October 4, 2017

**RE: Johnston-Lee-Harnett Community Action**  
**747 Shawtown Road**  
**Lillington, NC 27546**

**Re: Application Number – 17-50042230**

Project:
N/A
 Drawing:
SP1

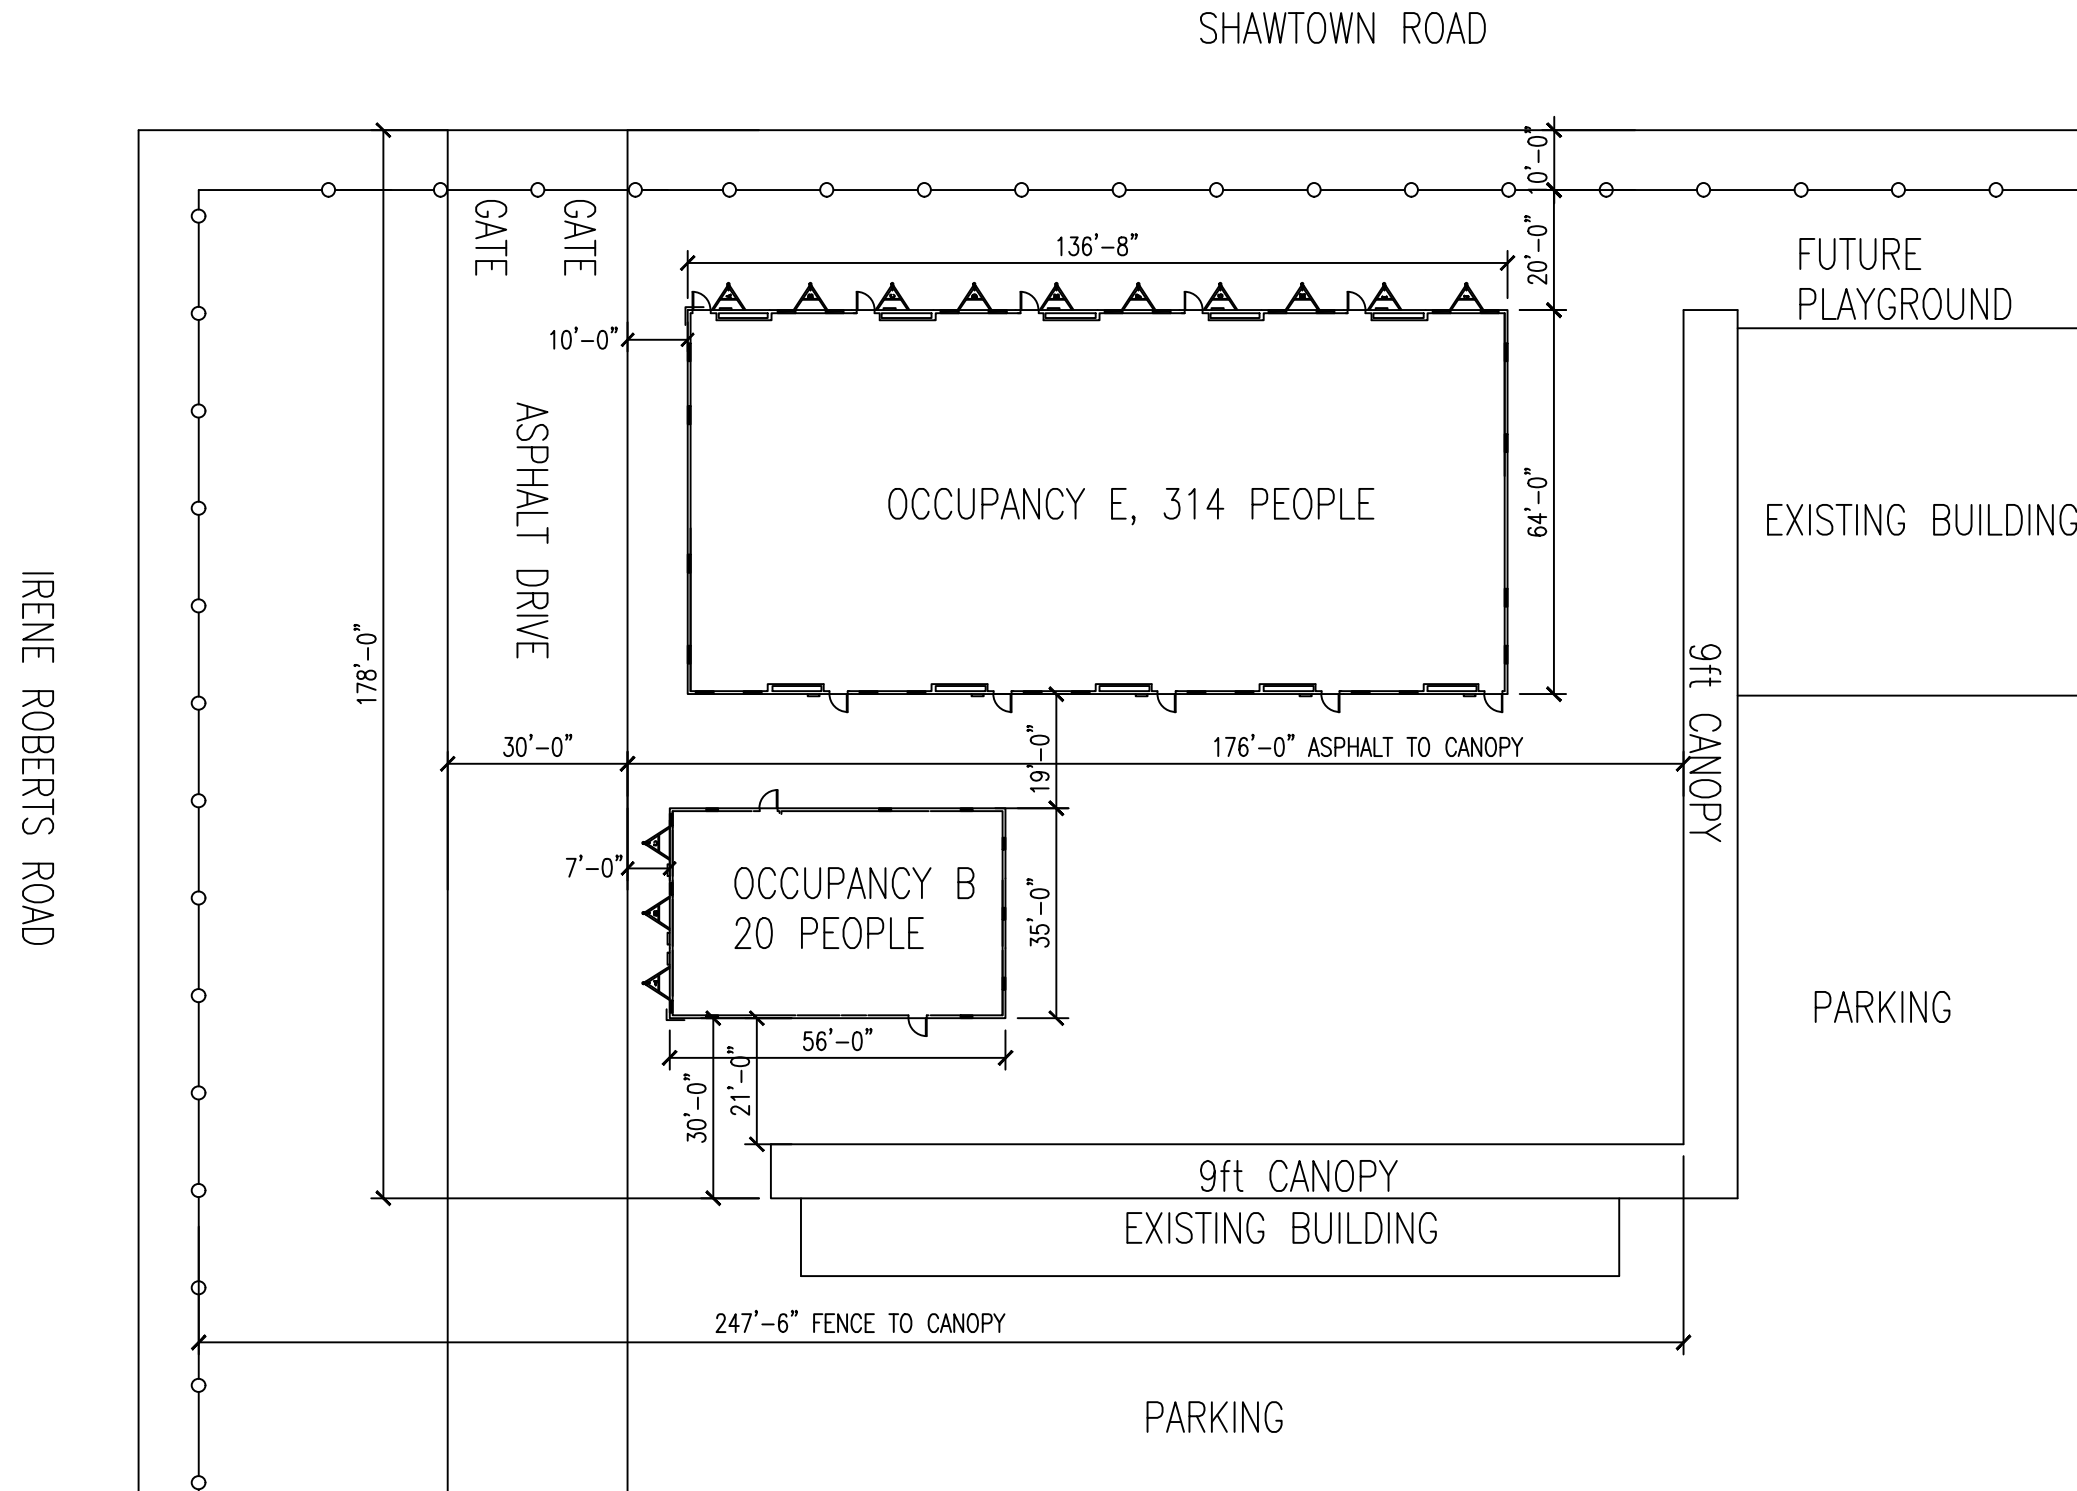
- **503 Fire Department Access**
    - The fire department access shall extend to within 150 feet of all portions of the facility (current driveway and parking lot may suffice).
    - The fire department access road shall be of an unobstructed width of not less than 20 feet and shall have an unobstructed vertical clearance of not less than 13 feet 6 inches.
